WEST SUSSEX COUNTY COUNCIL CONSULTATION

TO:	Arun District Council FAO: Anita Gardner
FROM:	WSCC - Highways Authority
DATE:	30 August 2019
LOCATION:	Wicks Farm, Ford Lane, Ford, Arundel, BN18 0DF
SUBJECT:	F/30/18/PL 2 multispans tunnels, 2 ancillary outbuildings, drainage pond, associated drainage works, external hardstanding for vehicle parking, access and turning. Additional highway report received.
DATE OF SITE VISIT:	28/01/2019
RECOMMENDATION:	More Information / Modification
S106 CONTRIBUTION TOTAL:	n/a

Rev	Description	Dm	Ch	Date
REVISIONS				
Preliminary	Approval	Tender	Consent	
DRAWING STATUS				
DATE	DRAWN	CHECKED	ISSUE CHECKBOX	
AUGUST 2019	BEB	DLW		
DRAWING No.	REV	SCALE		
6352.002	.	1:500	@ A3

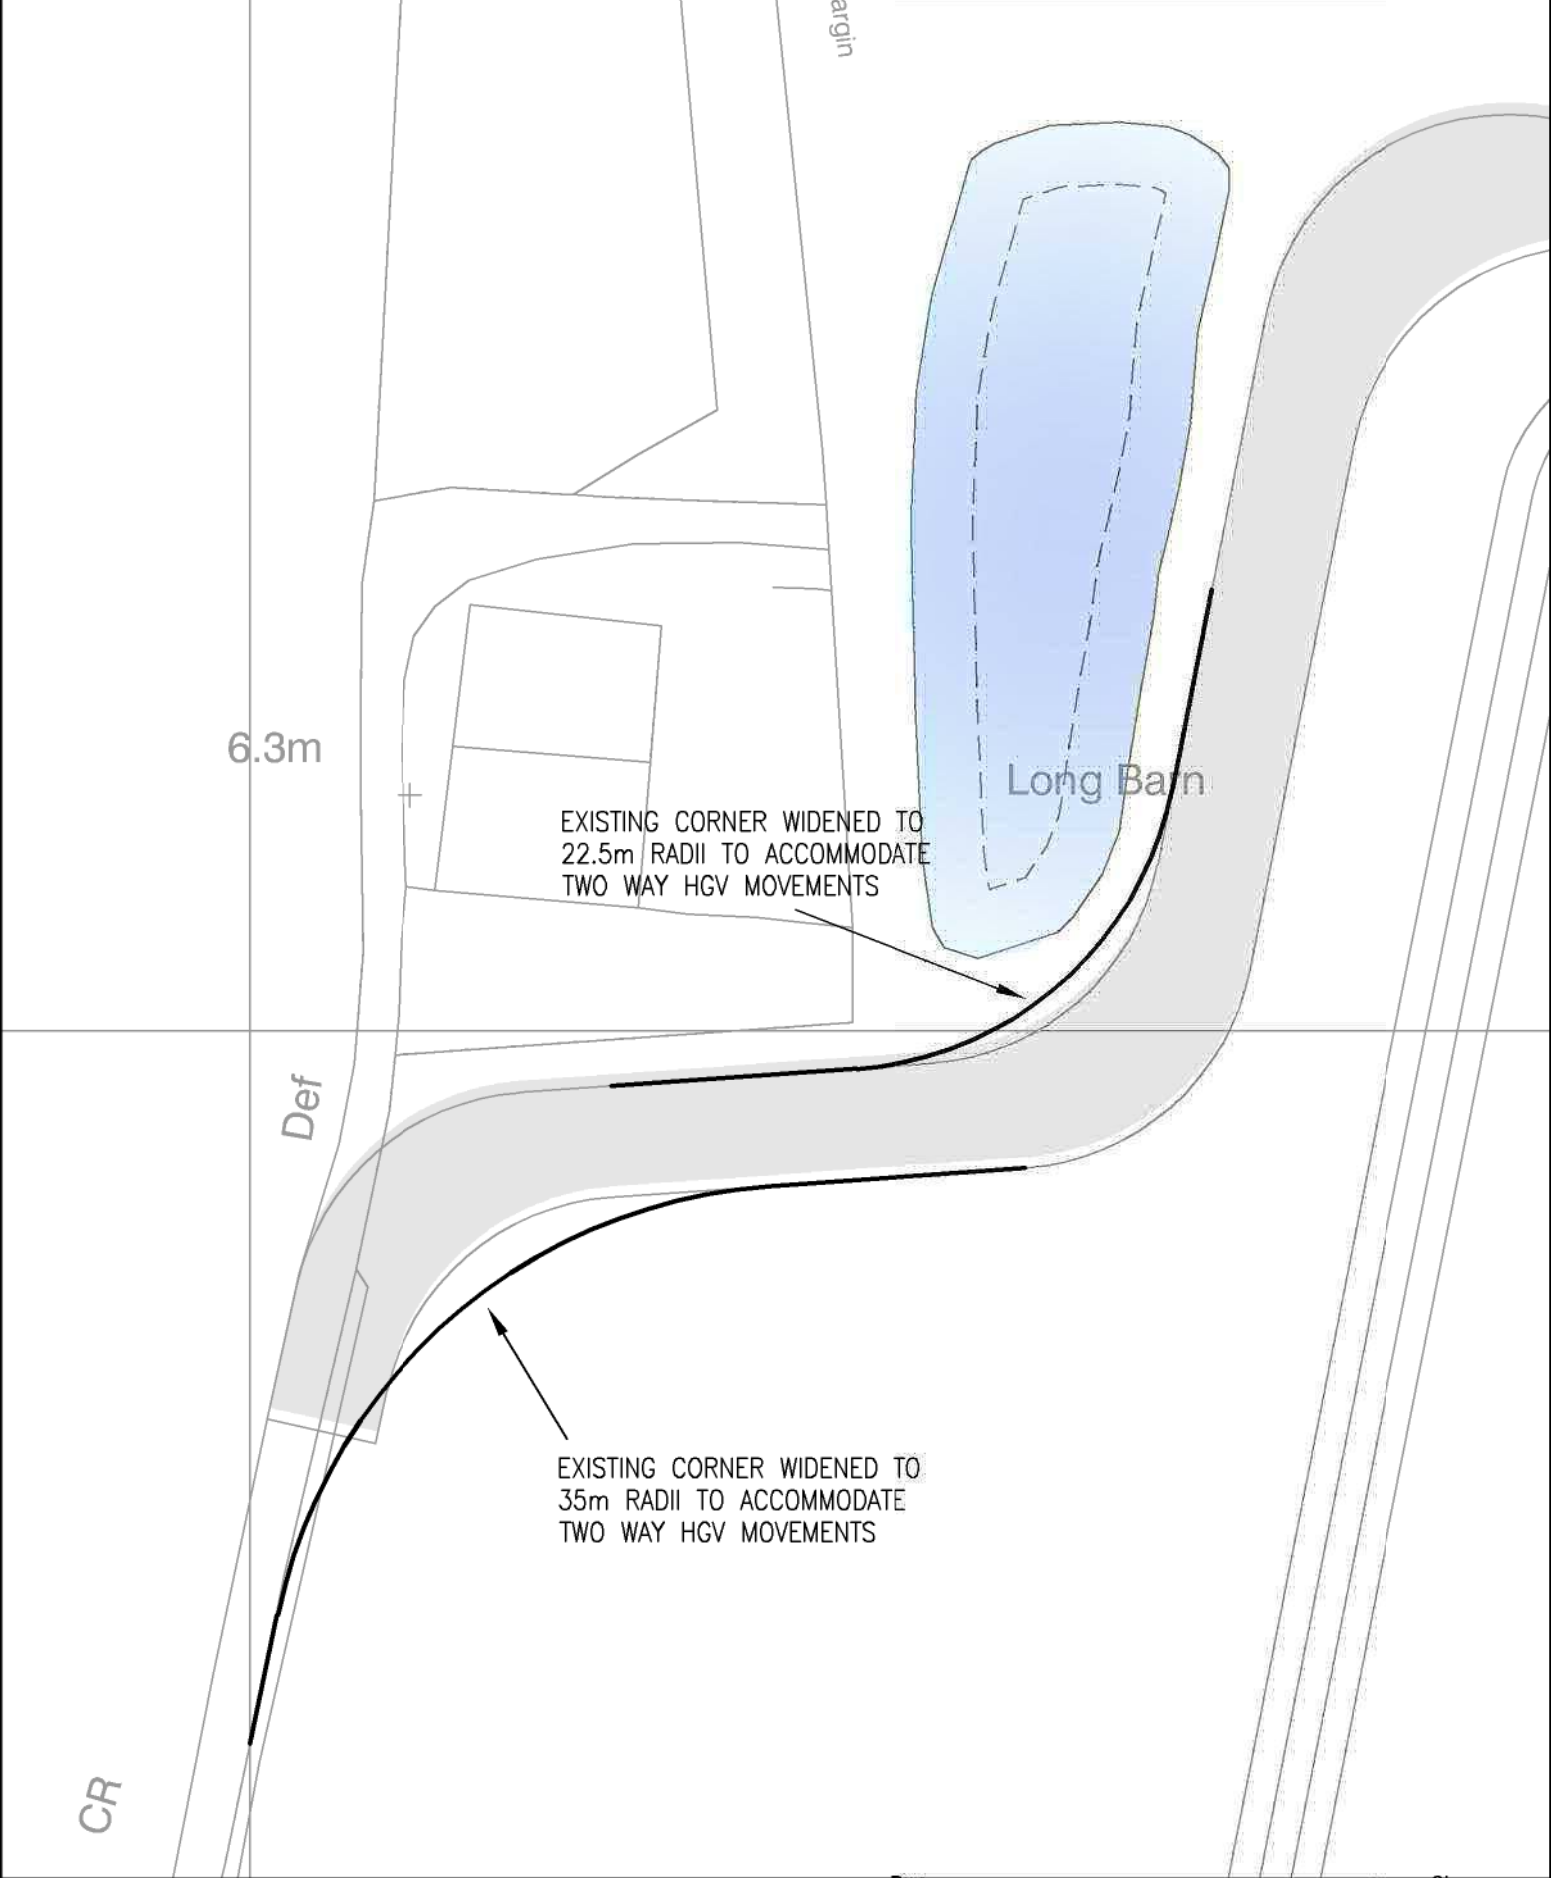
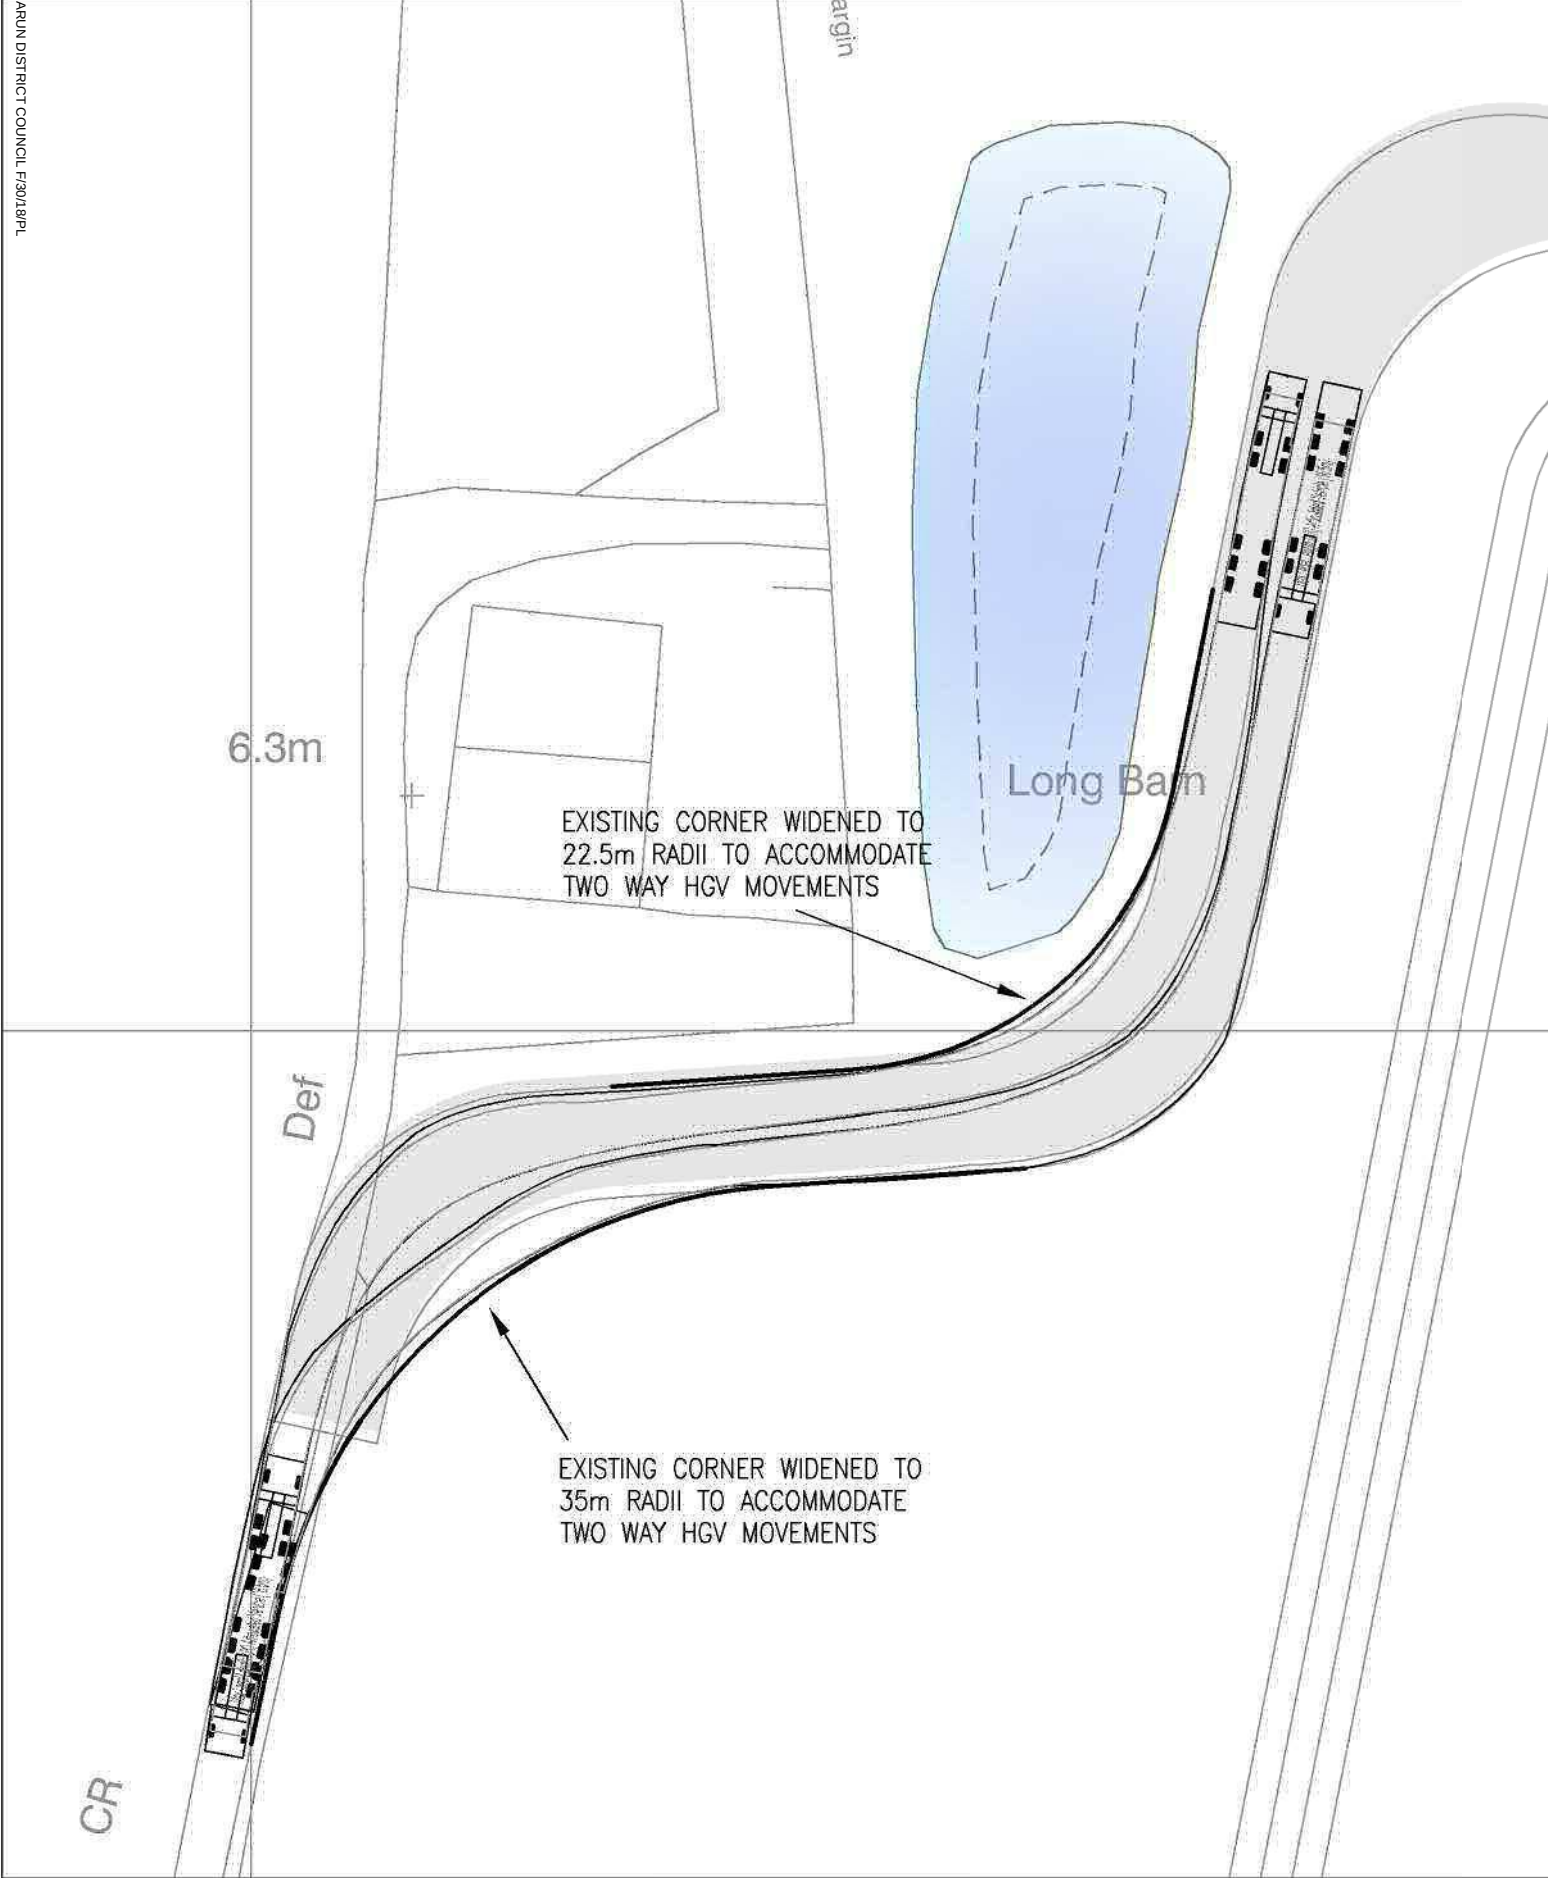
Swept path tracking has been provided demonstrating that HGVs can enter the site from both directions via the proposed widened access. Whilst it appears that HGVs can exit the site to the west, HGVs turning left out of the access are required to cross both the opposing carriageway and an access on the south of Ford Lane before returning to the correct side of the carriageway and proceeding east. This is not an acceptable arrangement and requires the use of land outside of the control of the applicant.

Removing the possibility of conflict with HGVs at the access may allow a vehicle exiting the site the possibility for an alternative road position to be taken up within the access route. This practise may facilitate an improved manoeuvre onto Ford Lane and may prevent vehicles overrunning the site access opposite.

The LHA note that the transport statement initially provided by the applicant, states that all HGVs will be routed east towards Ford Road, A27 and A259. Therefore this would be the manoeuvre that all HGVs exiting the site would be required to undertake. As such, whilst the access has been designed to accommodate two HGVs passing within the access, the LHA would request that the

applicant provide a detailed routing statement to ensure that two HGVs do not utilise the site access at the same time.

The revised statement should at least confirm that only one HGV will utilise the access at any one time, outline the proposed routing of vehicles entering and exiting the site, and confirm the frequency of HGV trips generated on a daily/weekly basis. The statement should also include details of when staff minibuses will be operational and details of how conflict will also be avoided with the HGV movements. Once this revised routing statement has been provided, the applicant should provide a revised swept path tracking plan for this manoeuvre to demonstrate any improvements.

The applicant may also wish to consider further access widening to facilitate an improved manoeuvre.
